Application no: H11-0065-11

Description: Installation of revised arched window on western elevation without complying with Condition 13 of H11-1218-07

Location: The Chapel Emporium
London Road
Long Sutton
Spalding Lincs
PE12 9EA
PE12 9EA

**RE: PROPOSED RETENTION OF LARGE ARCHED WINDOW ON WESTERN
ELEVATION AT 'THE CHAPEL EMPORIUM', LONDON ROAD, LONG SUTTON
FOR MR J FARROW**

ELEVATIONS AS PROPOSED

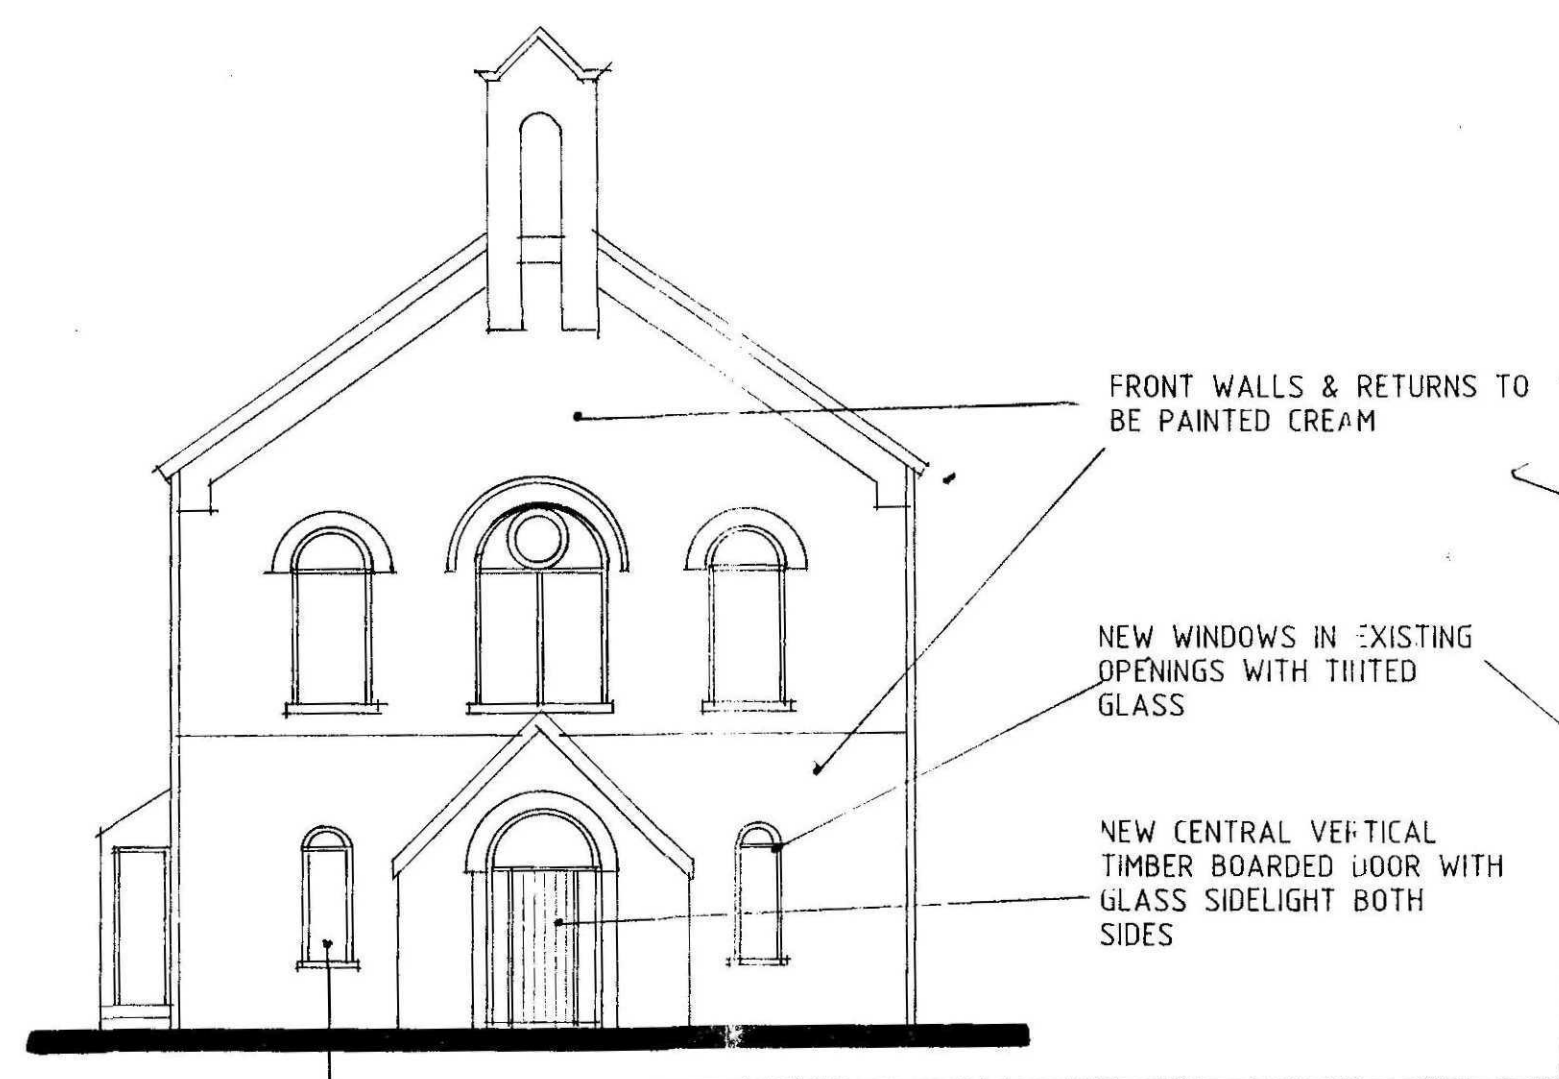
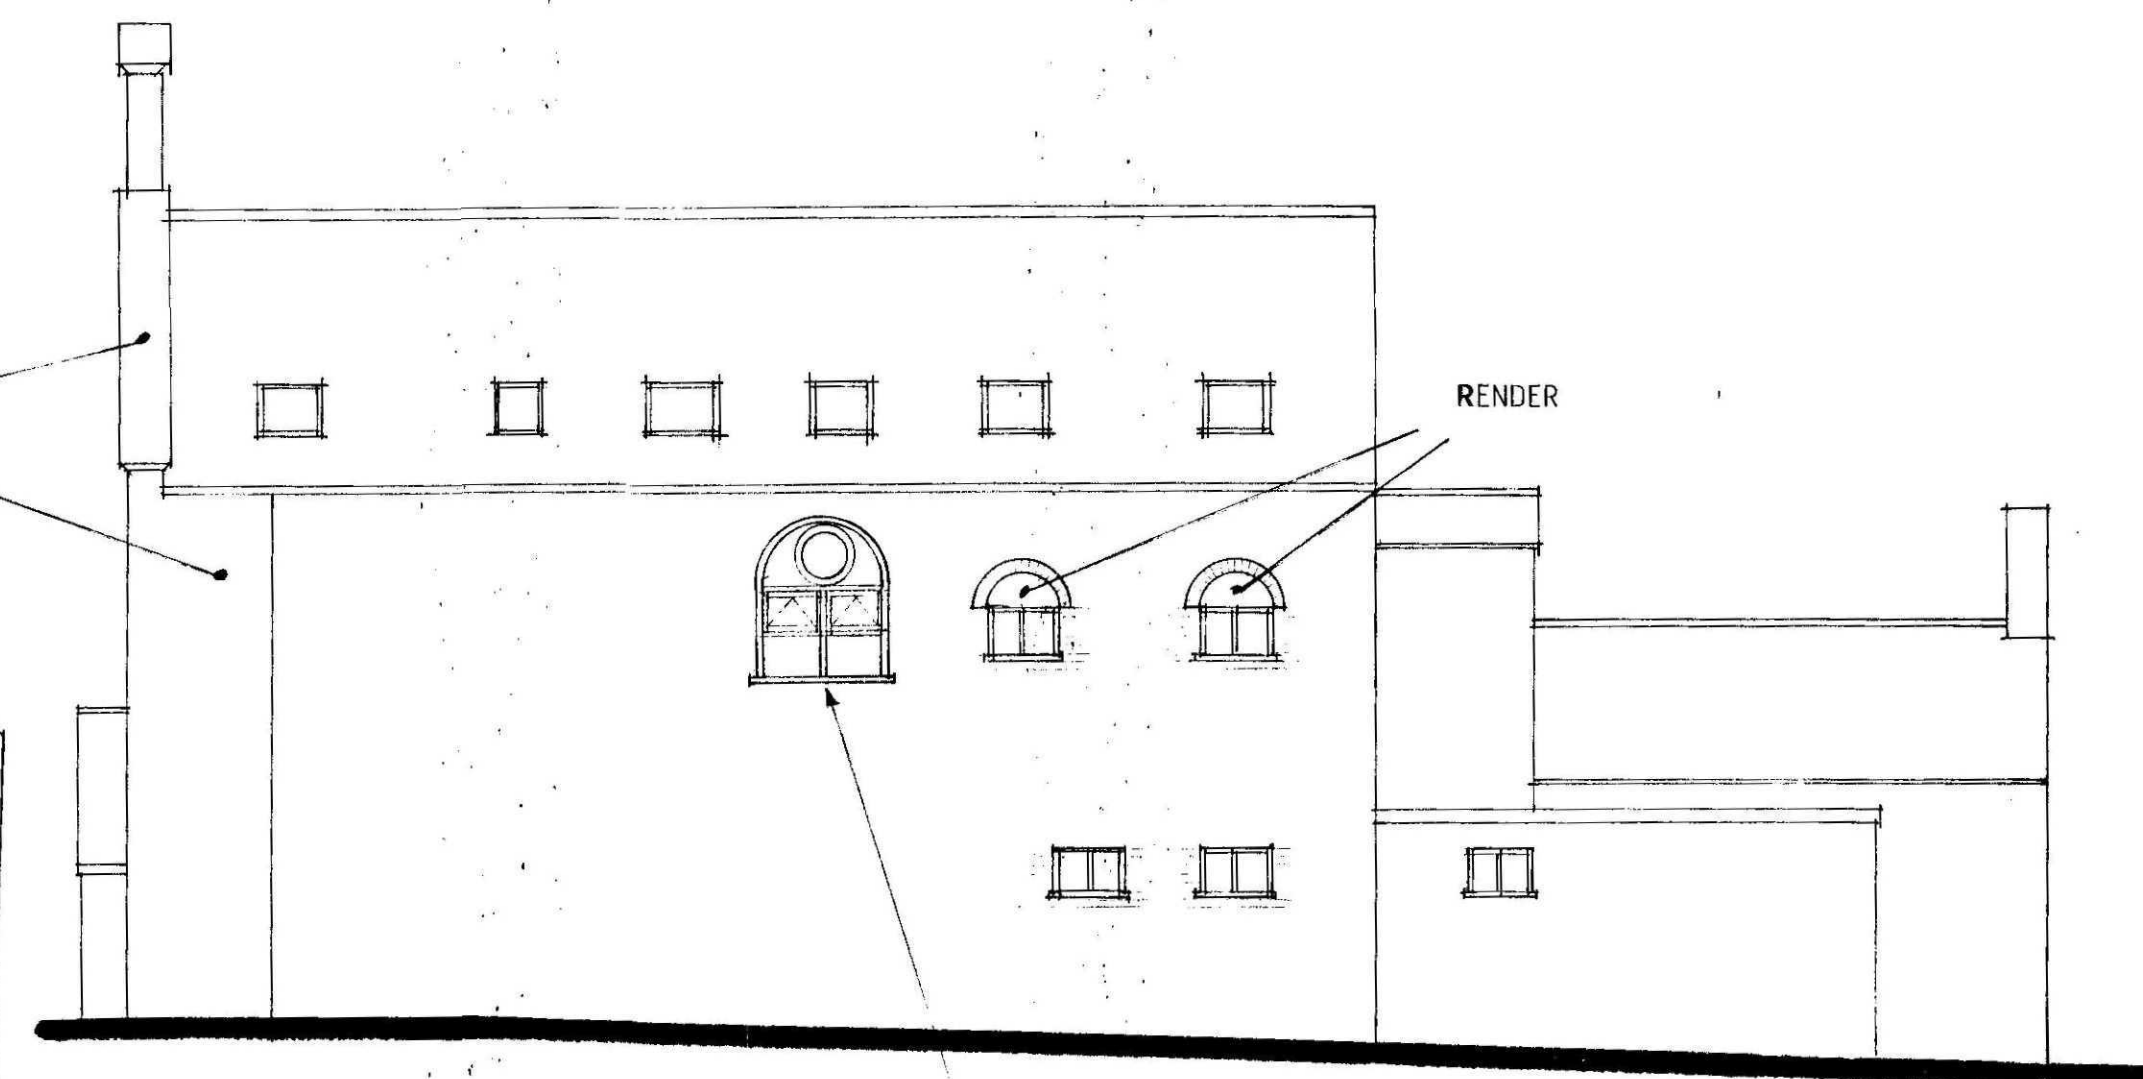
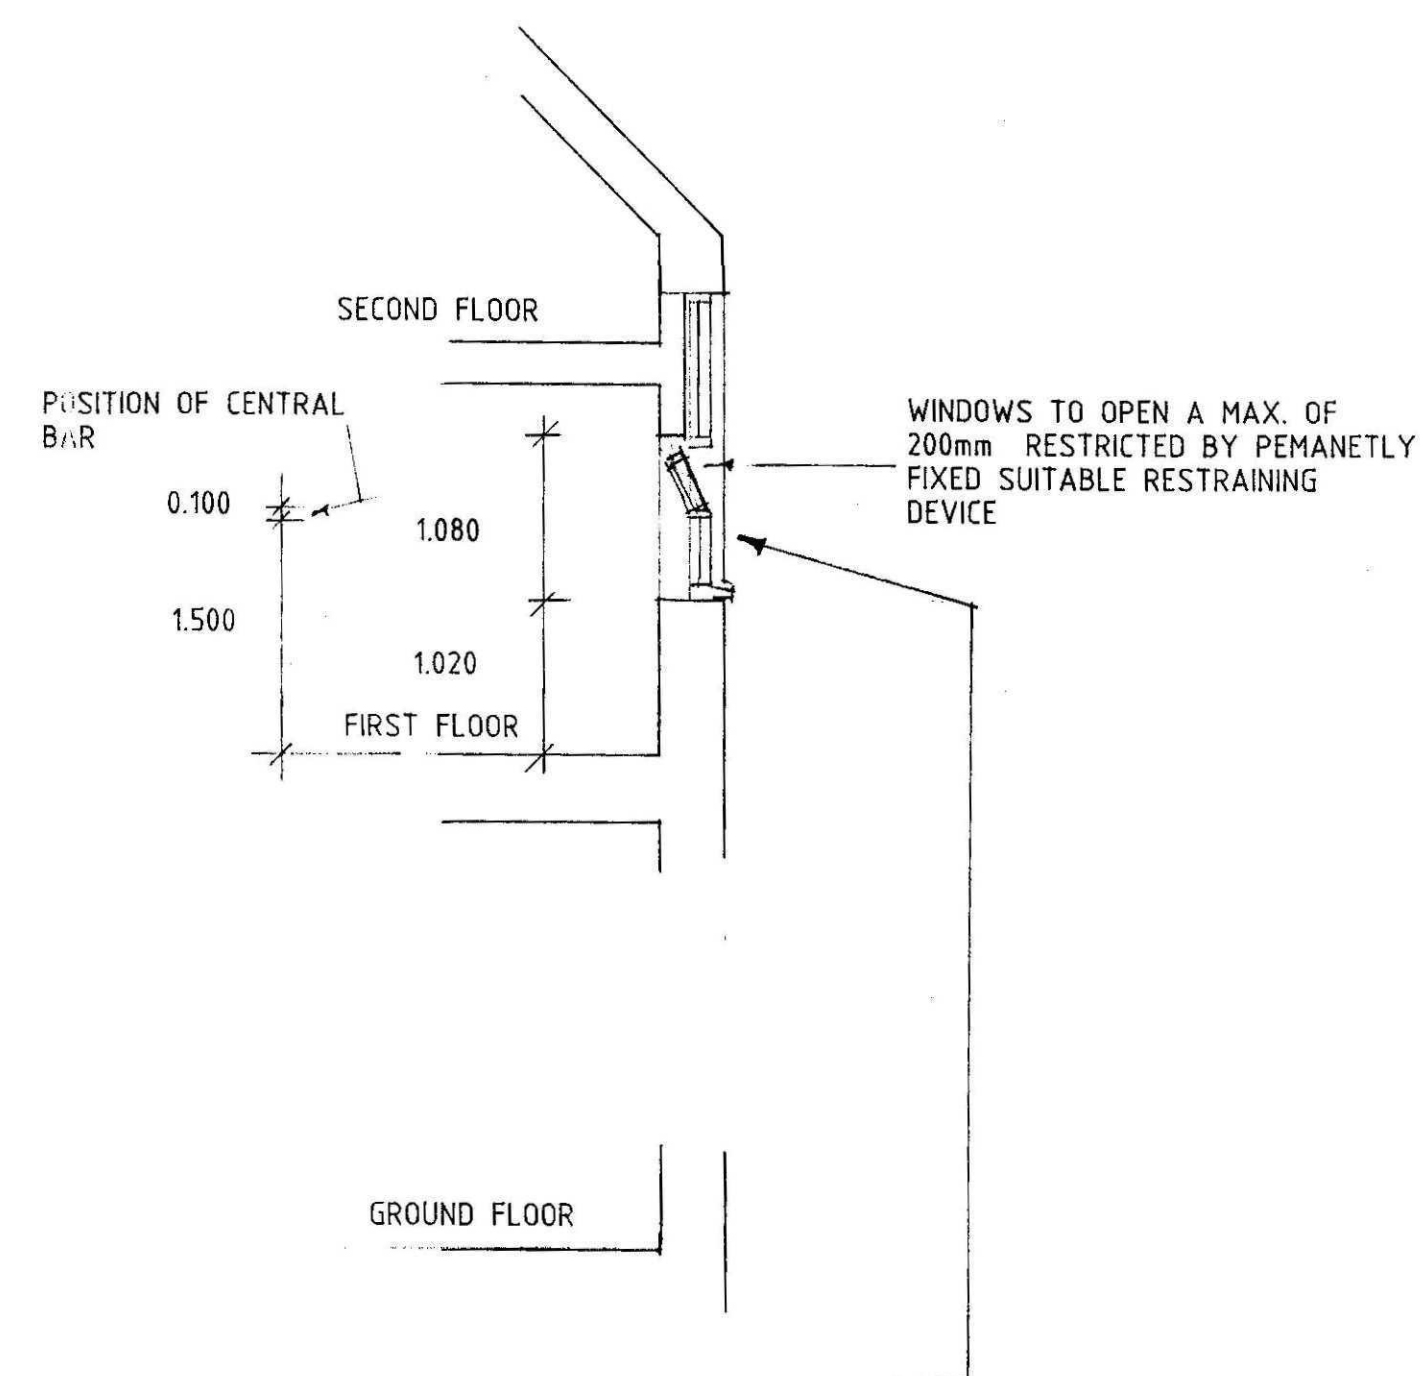
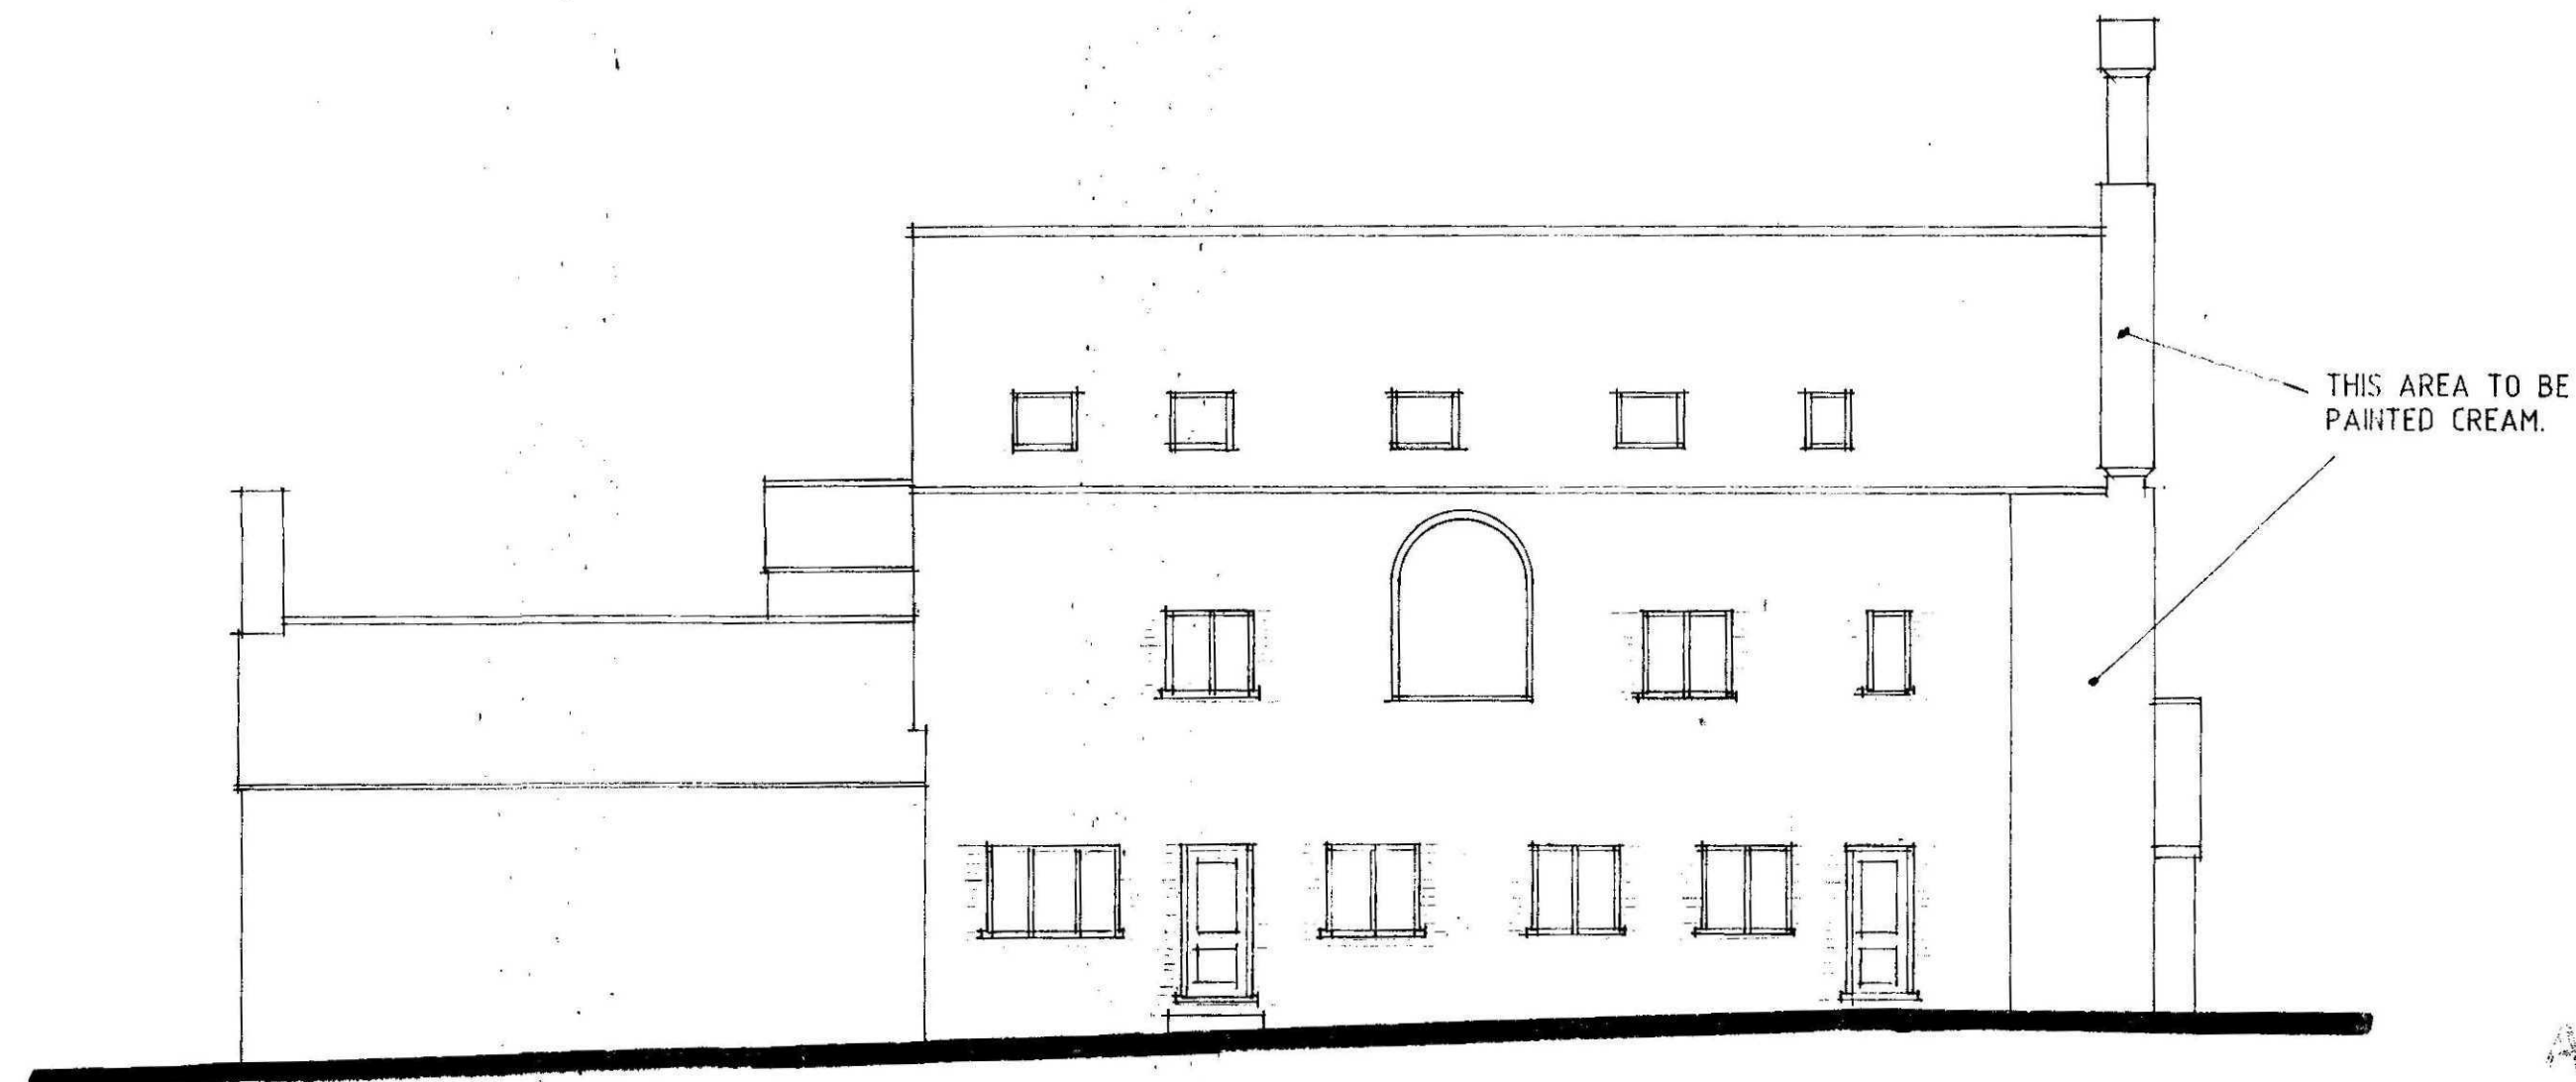
Amendment: Additional window details (dwg. no. SD07-005/3)

Further to your e-mail dated 9 February, I enclose 2 no copies of revised drawing no SD07-005/3G showing information as required.

It is considered that to have only one of the upper lights opening would give the window an unbalanced appearance and may not comply with Building Regulations for ventilation.
